REQUEST

Current Zoning: N1-A (Neighborhood 1-A) and IC-1 (Institutional Campus-1)
Proposed Zoning: N2-A(CD) (Neighborhood 2-A, Conditional)

Approximately 23.42 acres located along the east side of South Tryon Street and west side of Steele Creek Road, north of Hamilton Road.

The petition proposes to develop a vacant, wooded property in the Steele Creek community with up to 187 multi-family attached dwellings along with accessory uses permitted in the N2-A(CD) zoning district.

DRAWING NO.: **RZ-01**

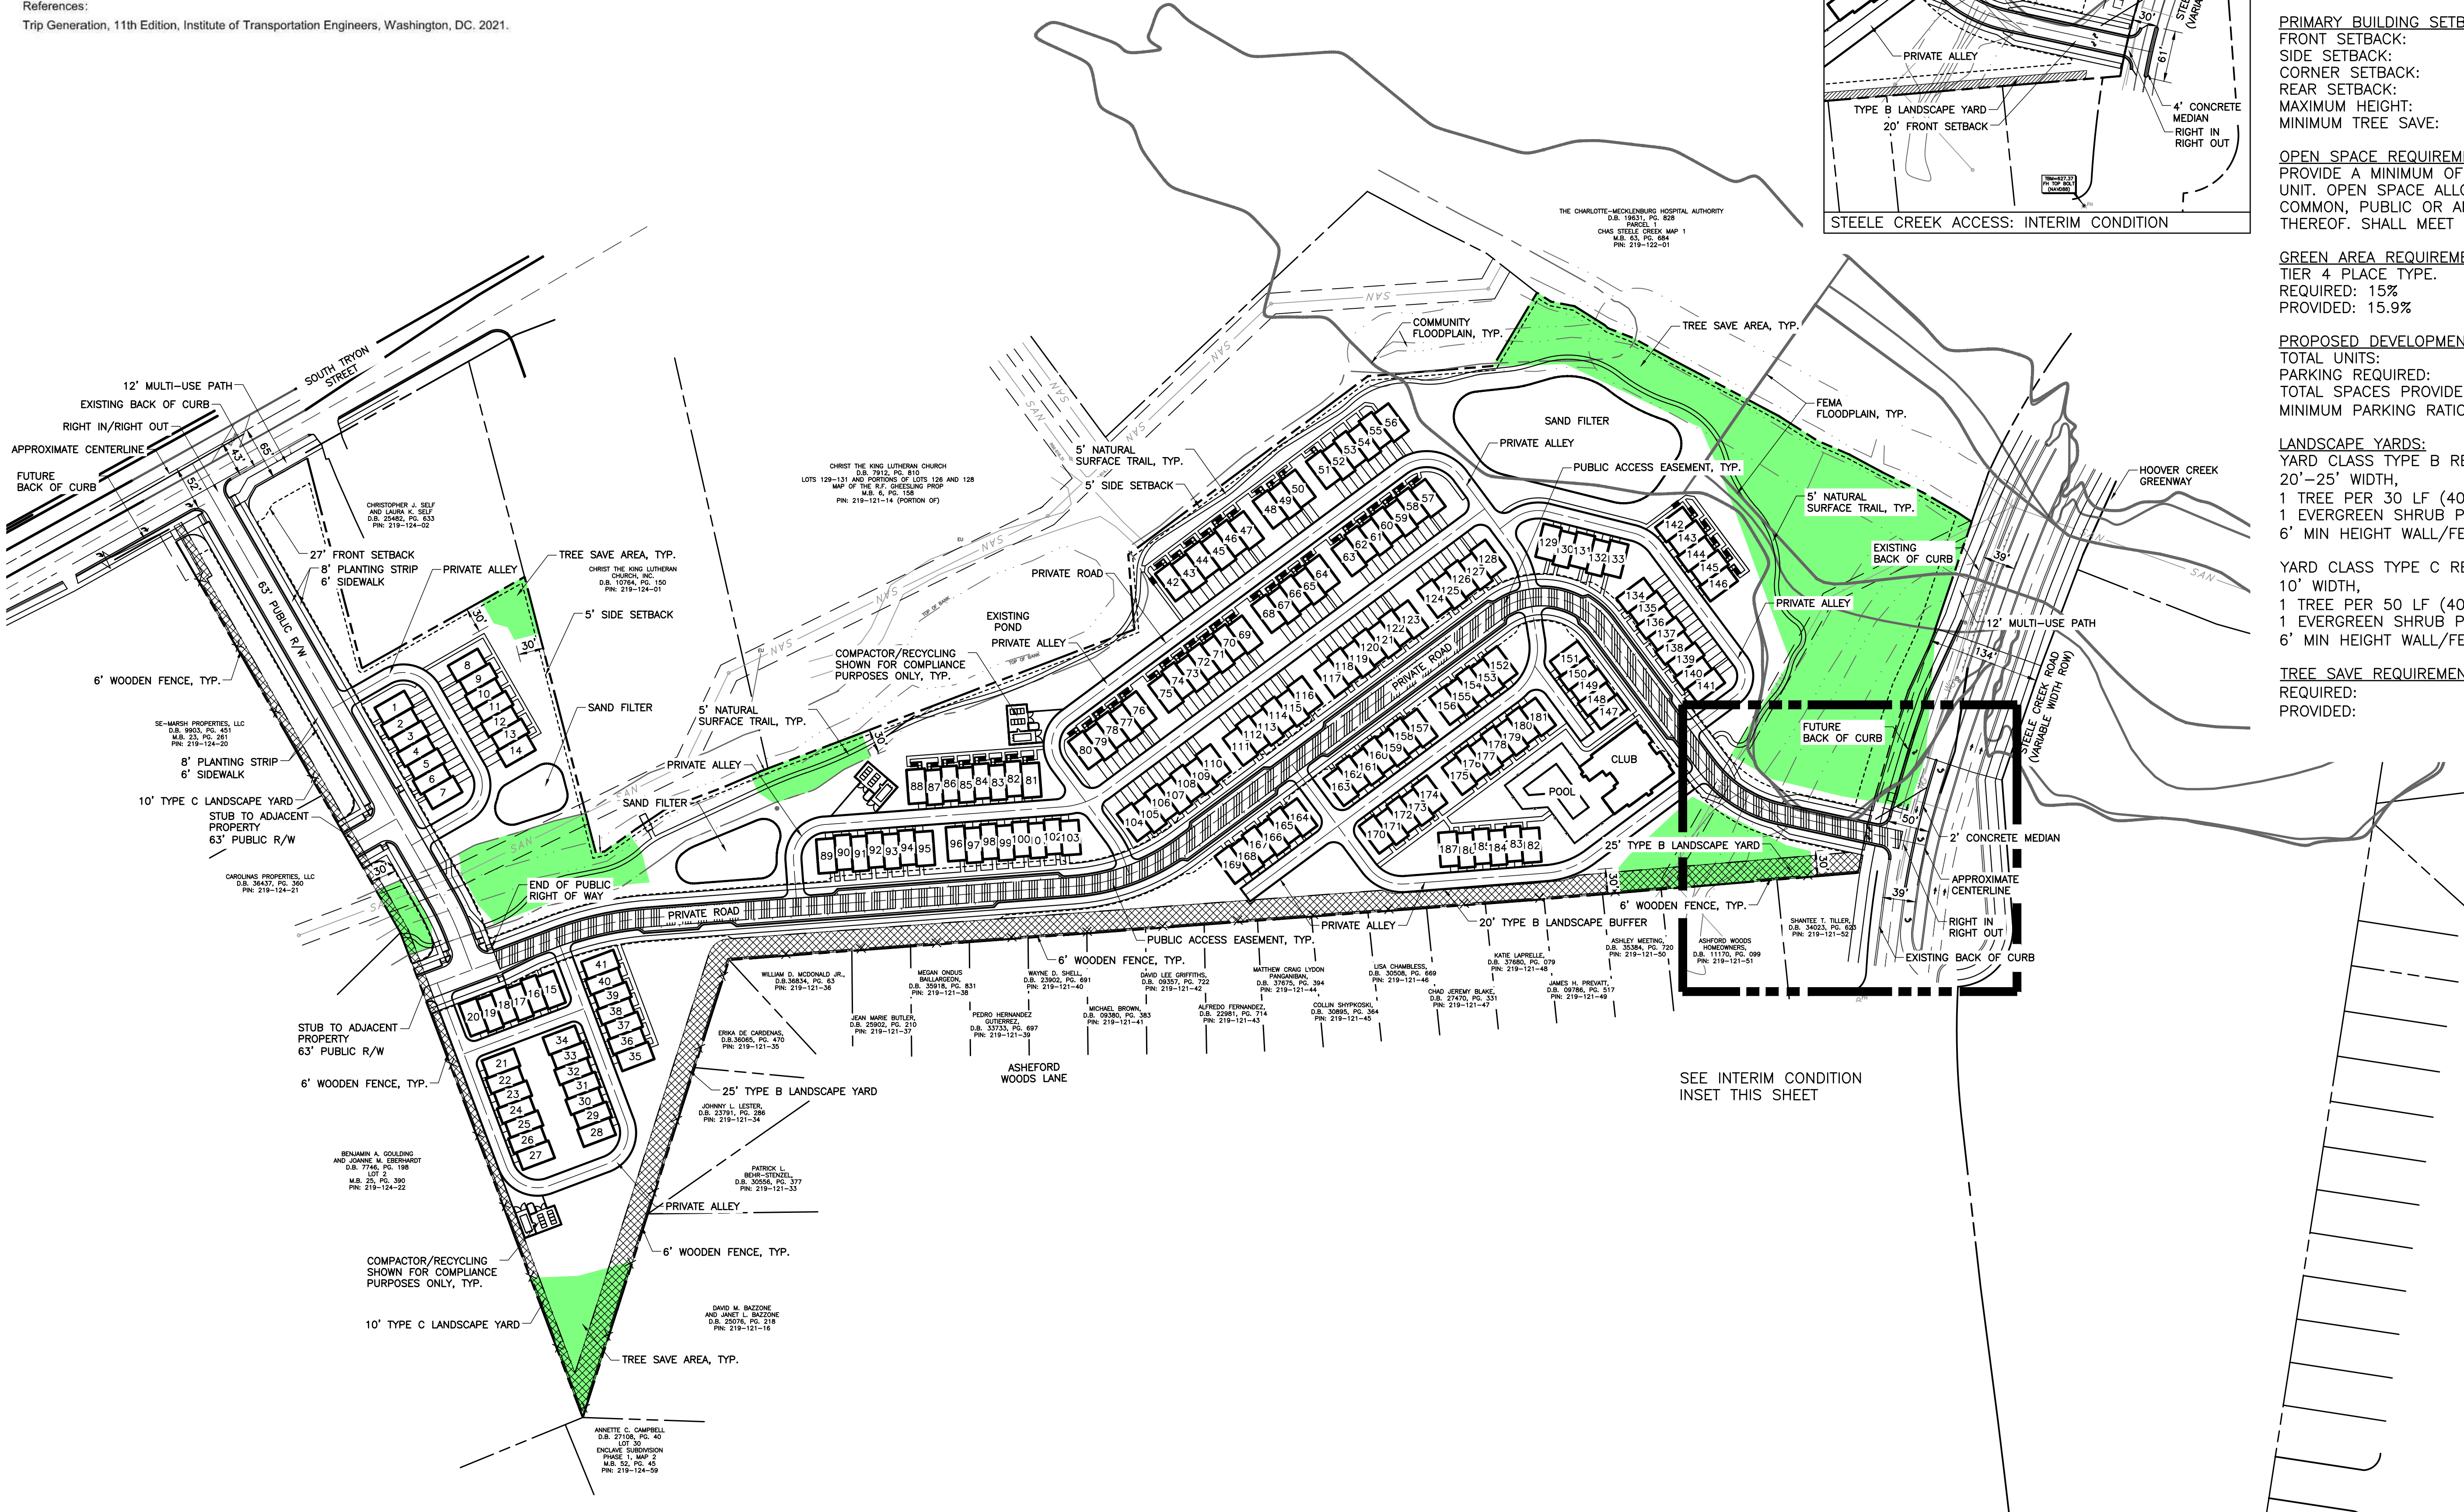
1. Provide a tree survey showing all city trees 8" DBH or greater and all planted city trees, all existing heritage trees on site, and any existing areas of the site used for credit toward meeting previously approved tree save or green area requirements.
2. Revise site plan to show that tree save areas are contiguous and a minimum of 30' wide.

3. Revise site plan to show interim condition on Steele Creek Road and screen in the final condition to be installed by NCDOT as part of the Steele Creek Widening Project. Callout concrete median on Steele Creek Road on the inset. Label and dimension the median length. Median should be shown to extend to 50' past radius returns at the new street connection.
